# DRIFTWOOD ESTATES FILING NO. 1

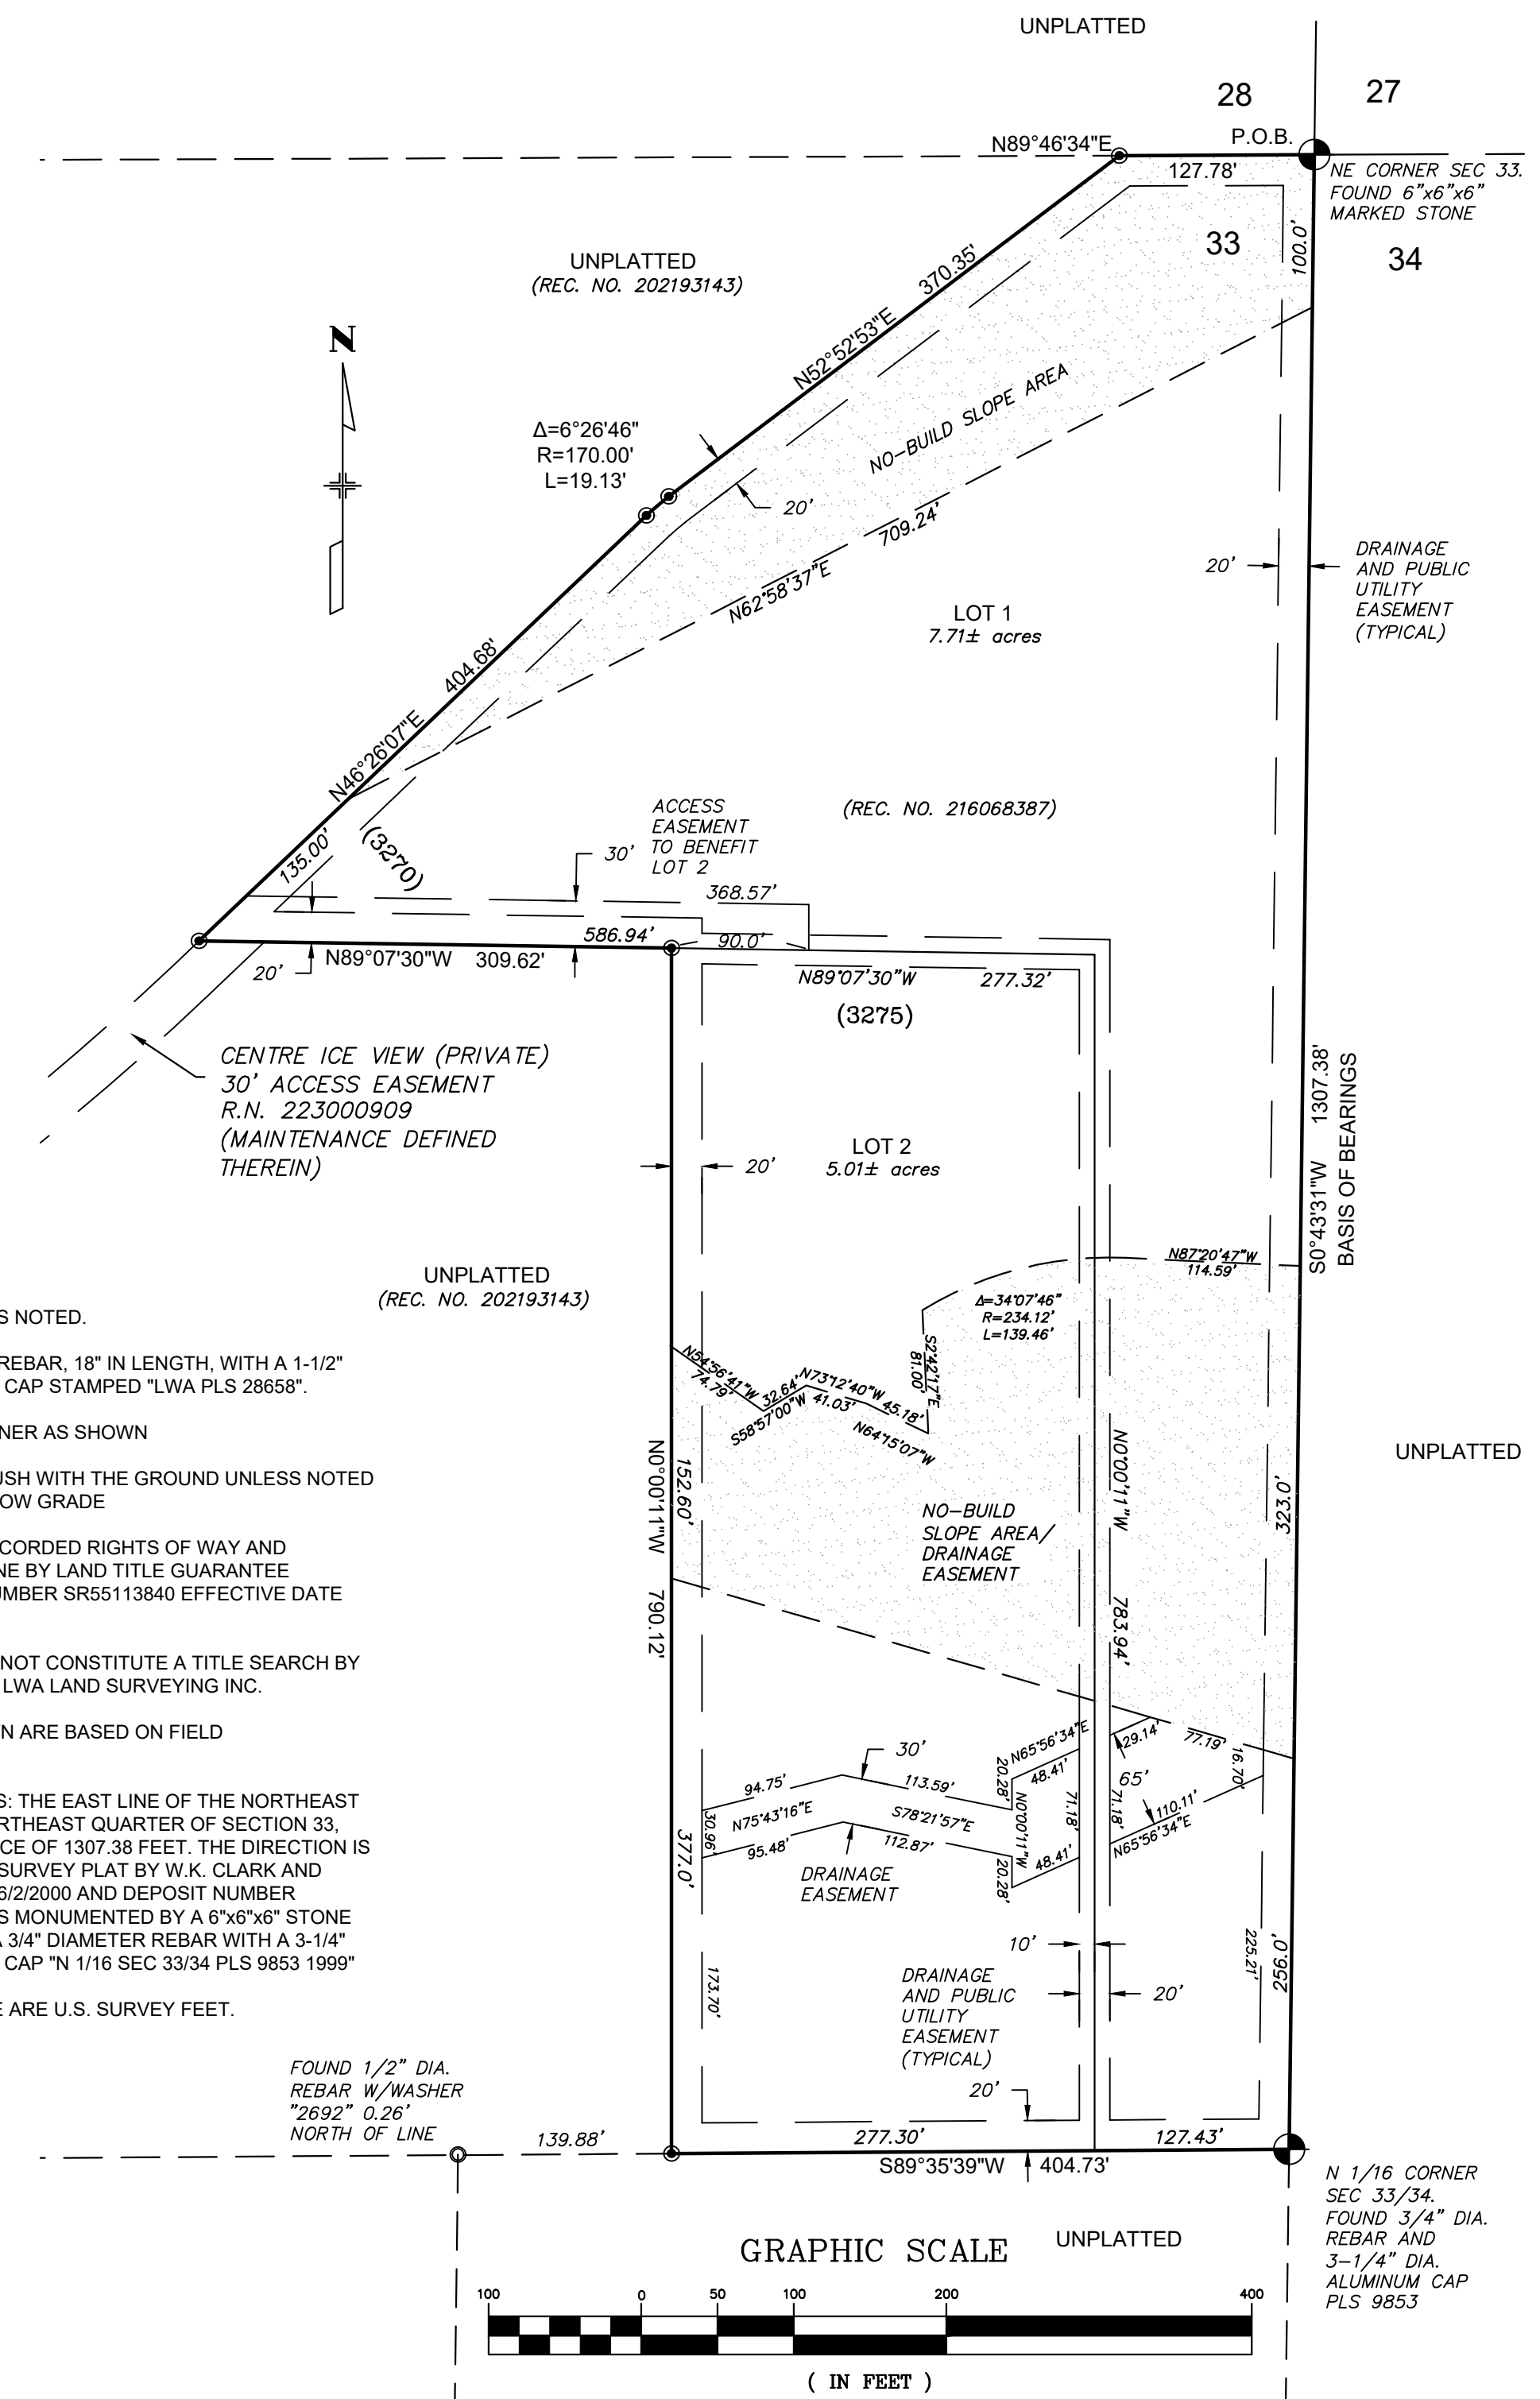
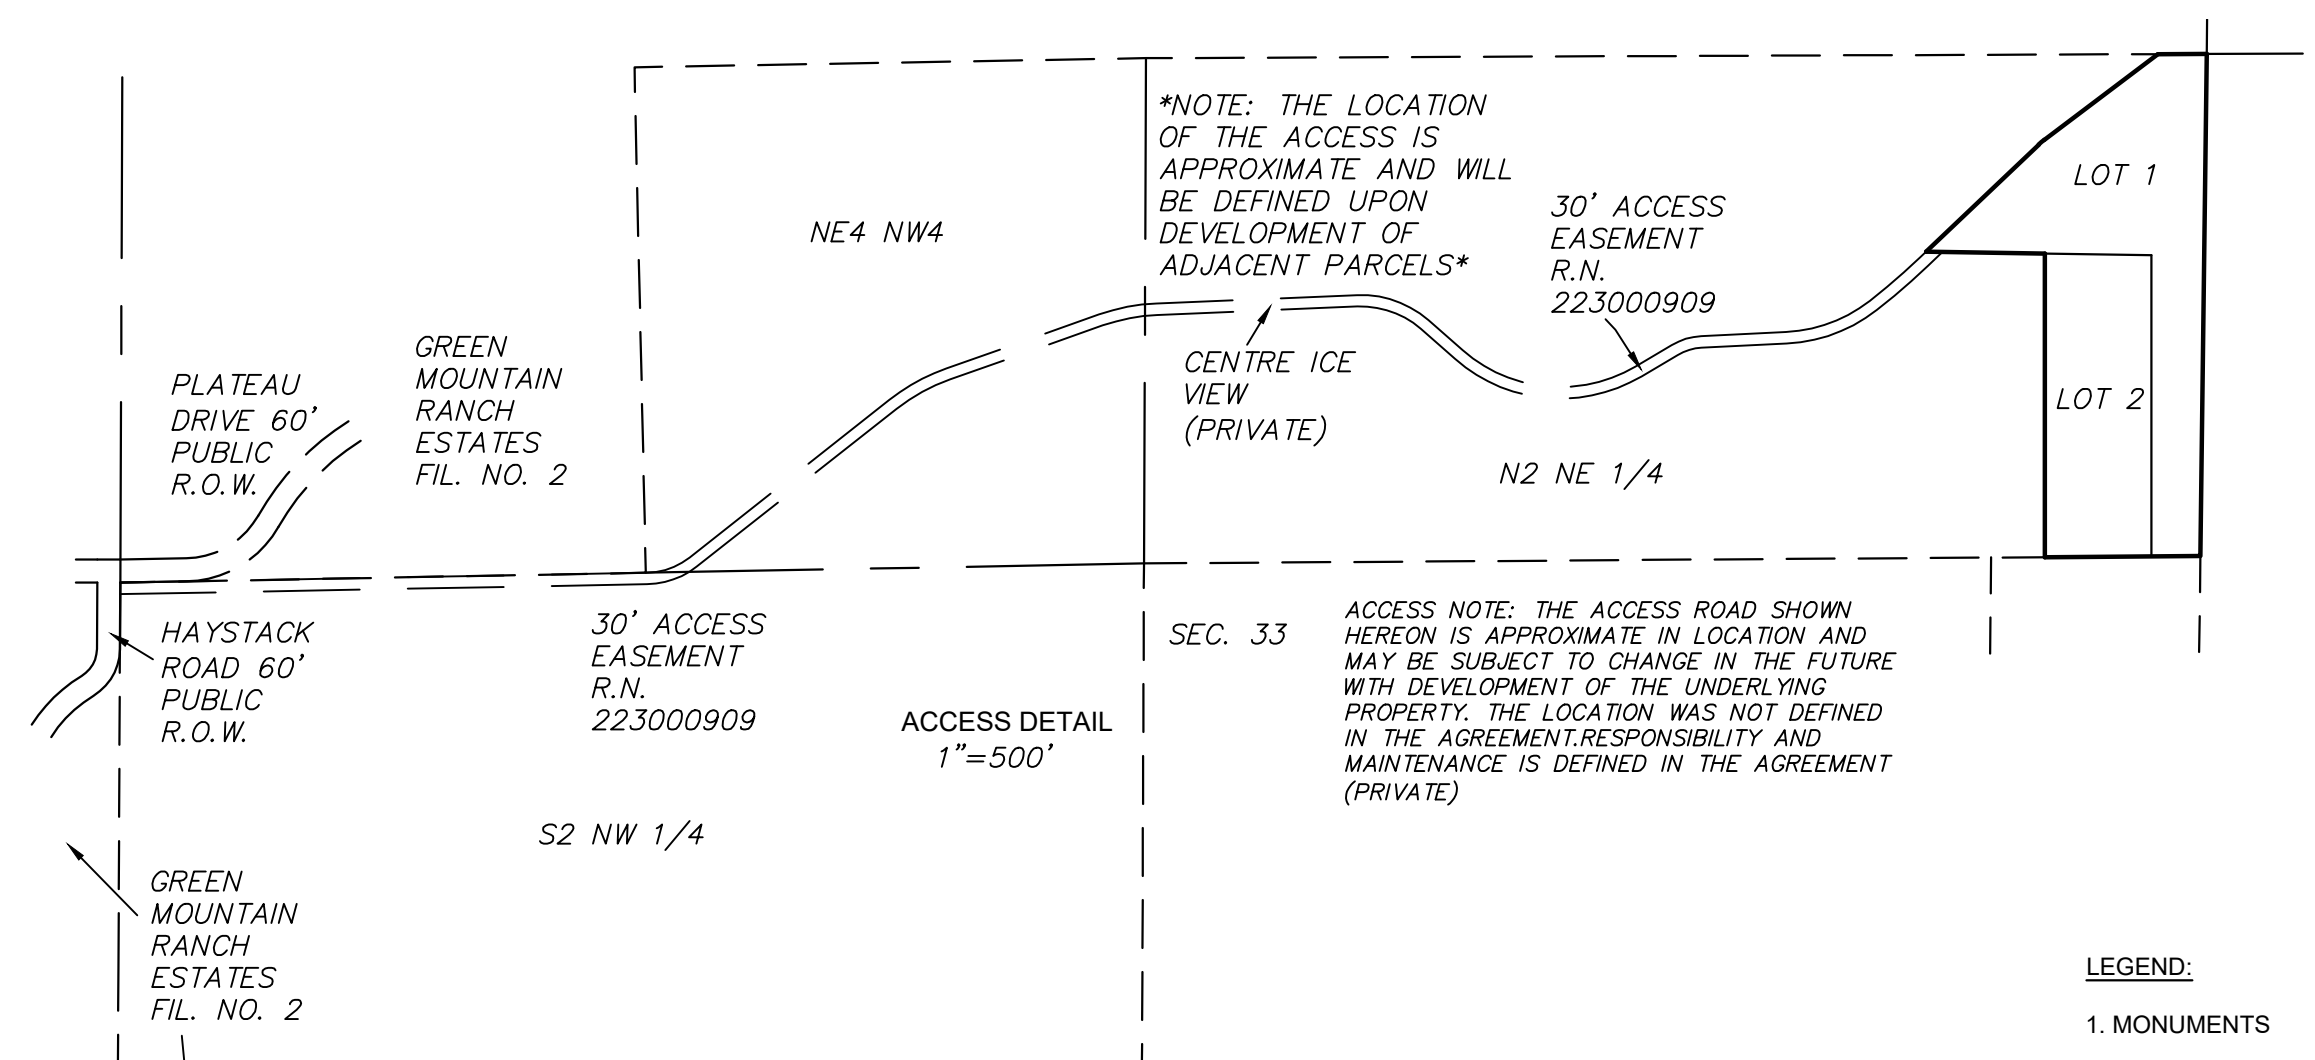
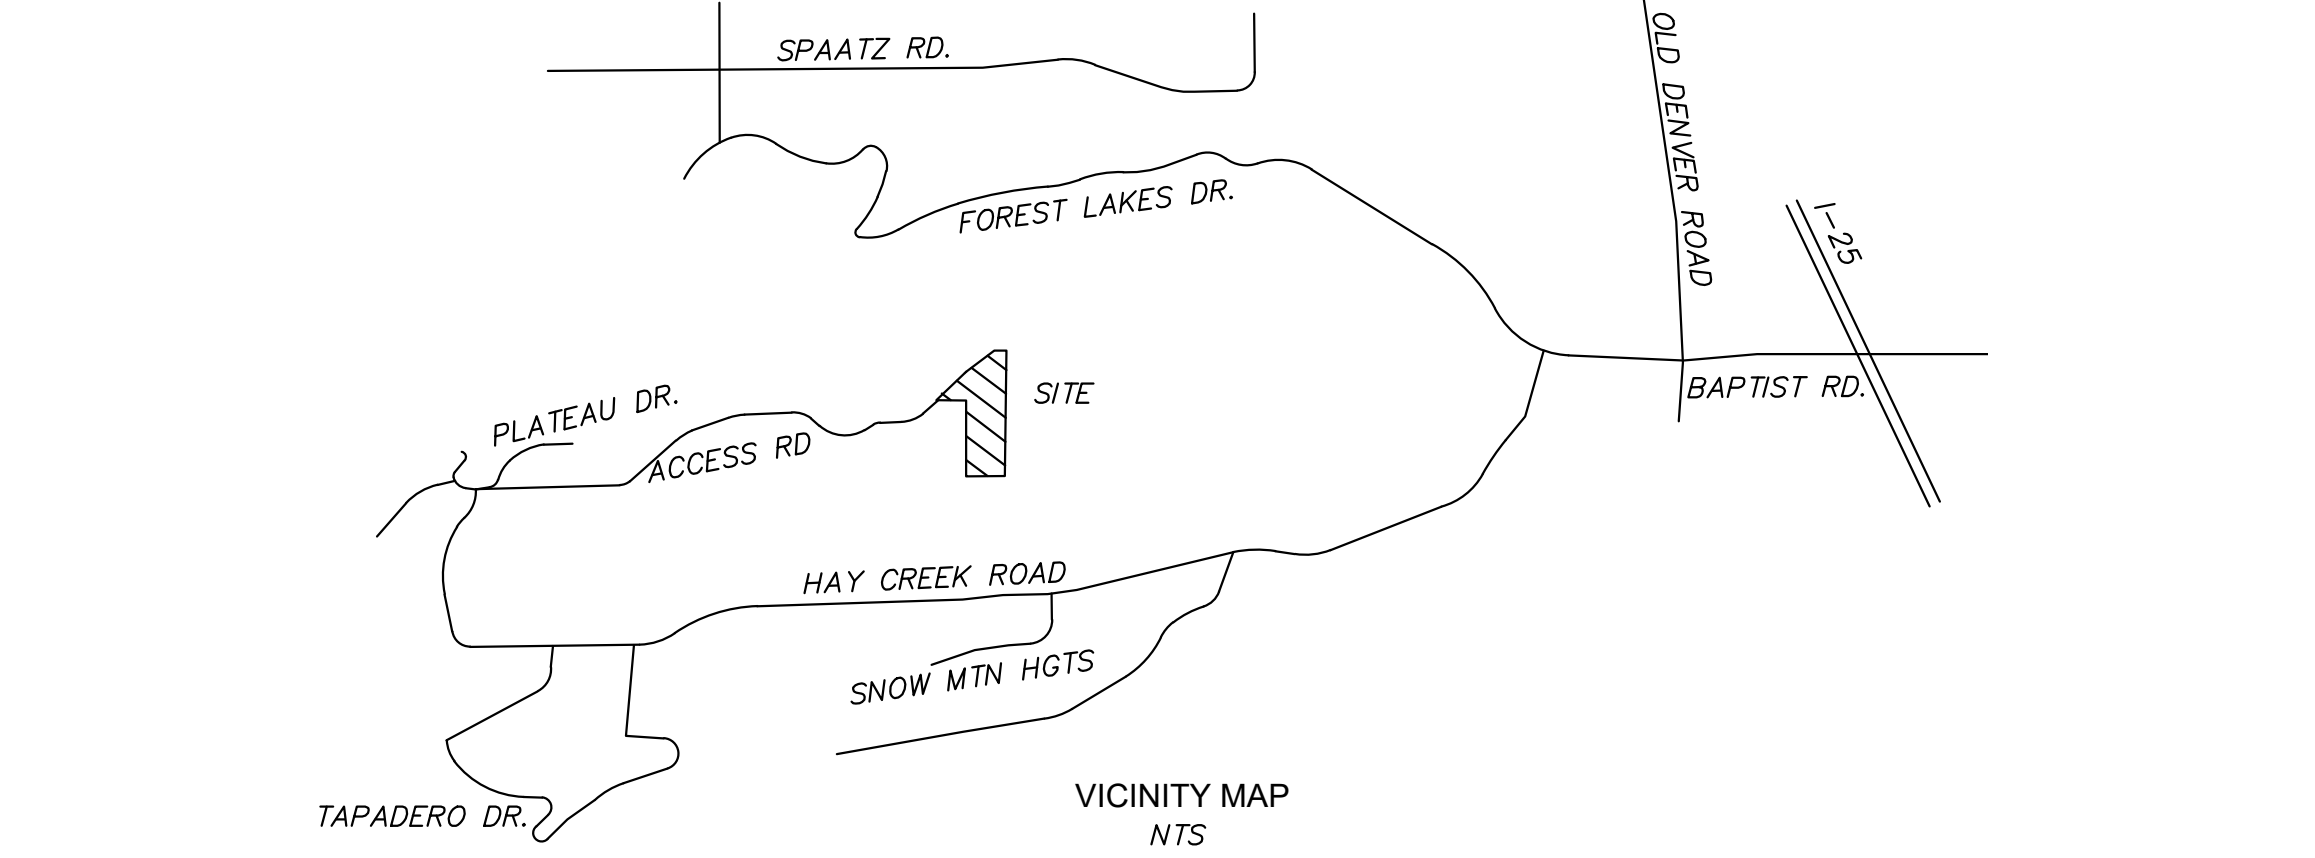
Label ROW lines, widths and street names of any existing and/or proposed private drives on Plat graphic.
Include description of maintenance responsibility

Add Addresses per Pikes Regional Building Dept.
Lot 1: 3270 Center Ice View
Lot 2: 3275 Center Ice View

Suggestion:
Replace "Notes" with "Legend"

Include "Total Acreage Table"
Total Acreage:
Lot 1 = 7.71 Acres
Lot 2 = 5.01 Acres
Total = 12.72 Acres

All imperviousness associated with the proposed driveway access must be included in the 10% lot imperviousness for the area associated with the disturbance to qualify for the large lot single family PBMP exclusion. The qualifications for this exclusion is presented in the ECM section 1.7.1.B.5:

"Large Lot Single Family Sites. A single-family residential lot, or agricultural zoned lands, greater than or equal to 2.5 acres in size per dwelling and having a total lot impervious area of less than 10 percent. A total lot imperviousness greater than 10 percent is allowed when a study specific to the watershed and/or MS4 shows that expected soil and vegetation conditions are suitable for infiltration/filtration of the WQCV for a typical site, and the permittee accepts such study as applicable within its MS4 boundaries. The maximum total lot impervious covered under this exclusion shall be 20 percent."

Add a note to the plat acknowledging that per ECM section 1.7.1.B.5, the residential lots impervious area may not exceed 10 percent unless a study is prepared in compliance with the requirements laid out in the above ECM section and the impervious area may not exceed 20 percent. This impervious area for each lot must include the proposed driveway.
